EROSION AND STORMWATER QUALITY CONTROL PERMIT (ESQCP) EL PASO COUNTY APPLICATION AND PERMIT

EPC Project Number: add text: PPR2225

PROJECT INFORMATION		
Project Name: Kum and Go Gas and C-Store	Date: 10-03-2022	PPR-2225 PCD File No.

Sign Plan_V2.pdf Markup Summary

40' FLAG POLE w/ FLAG

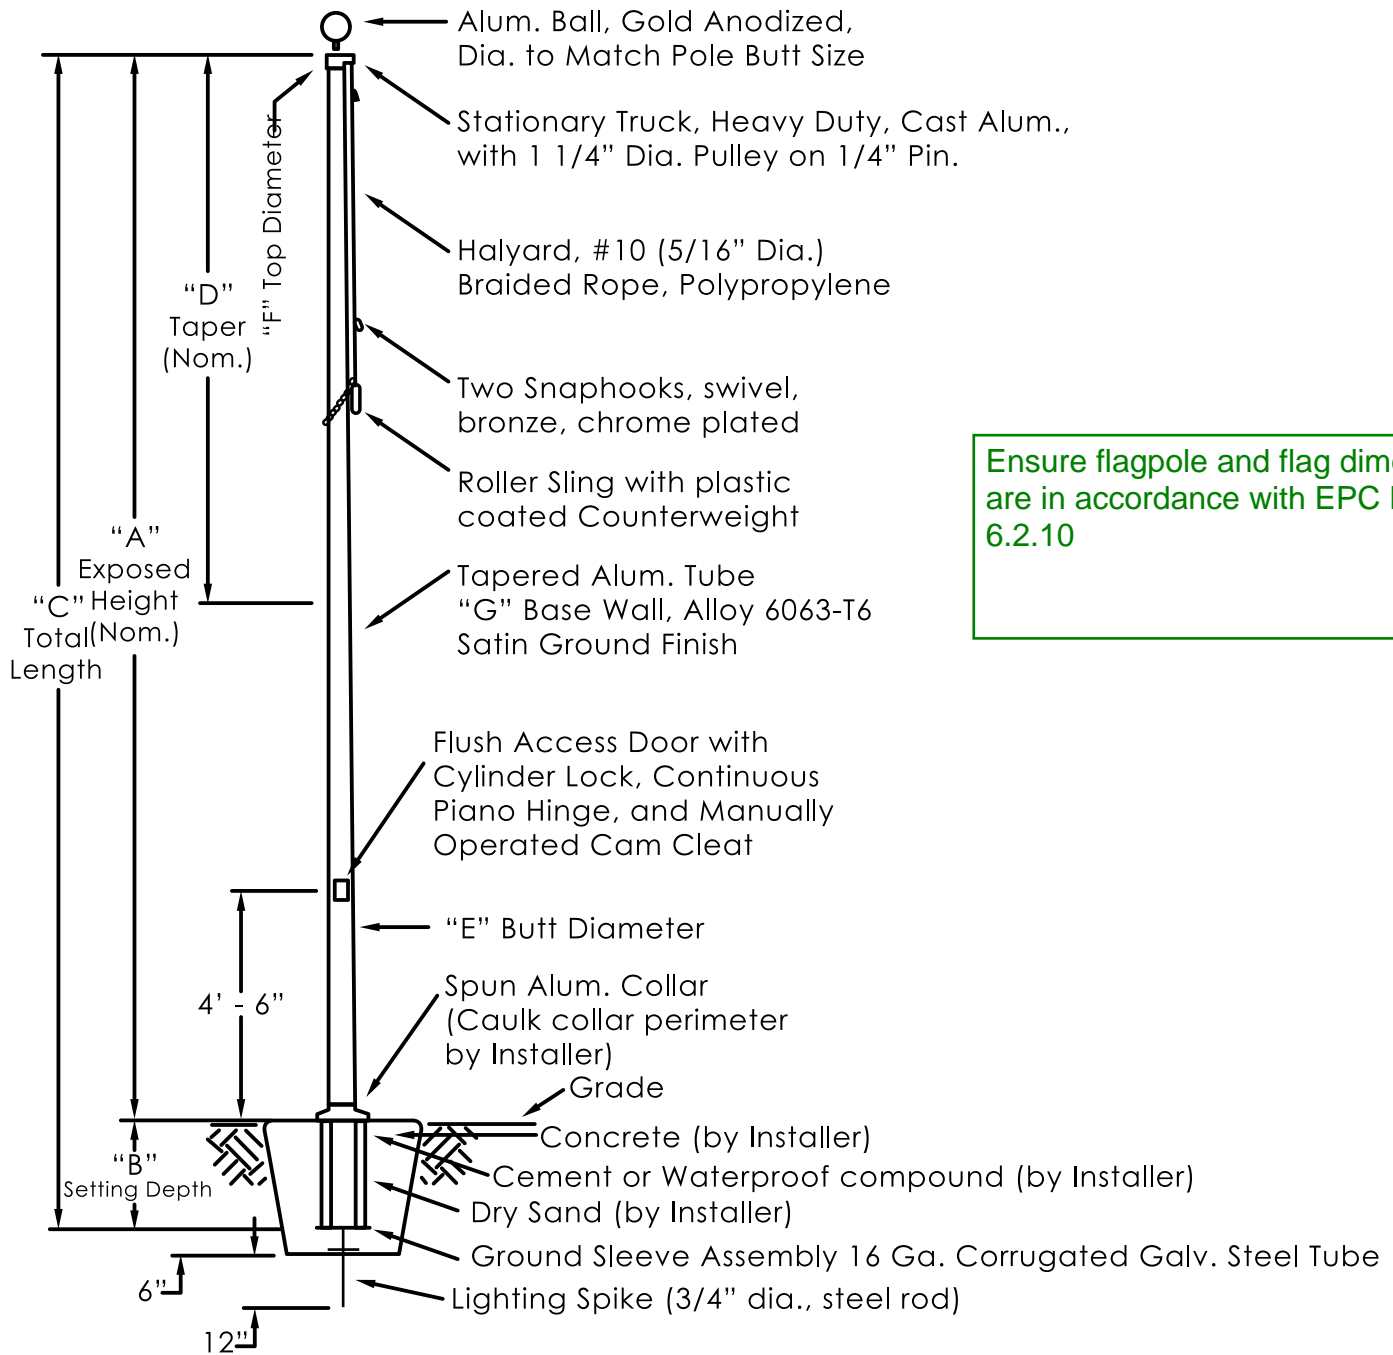
Exposed height from grade?

Conflicts with height called out on SDP. Provided proposed SF of flag. Allowed/proposed see below.

- (d) Flagpoles and Flags. Flags are considered signs and shall meet all standards for signs except as otherwise provided for by this Section.
- (i) Area of Flag Limited. The area of the flag shall not exceed 40 square feet or 2 square feet of sign for each linear foot of building wall area the flag is adjacent or closest to, whichever is less. The allowable area of freestanding signage shall be reduced by the size of the flag.
- (ii) Intrusion into Setback Area. A flagpole may be located within the setback area provided it is located within 10 feet of a building and is not within a utility, drainage, or access easement.
- (iii) Height of Flagpole. No flagpole shall exceed 20 feet in height if located within a setback area or the maximum height for the zoning district if located outside the setback area.

Addressed.
Removed flag pole
from project. no
references or
details shown on
site plan.

Addressed.
Removed flag pole
from project. no
references or
details shown on
site plan.
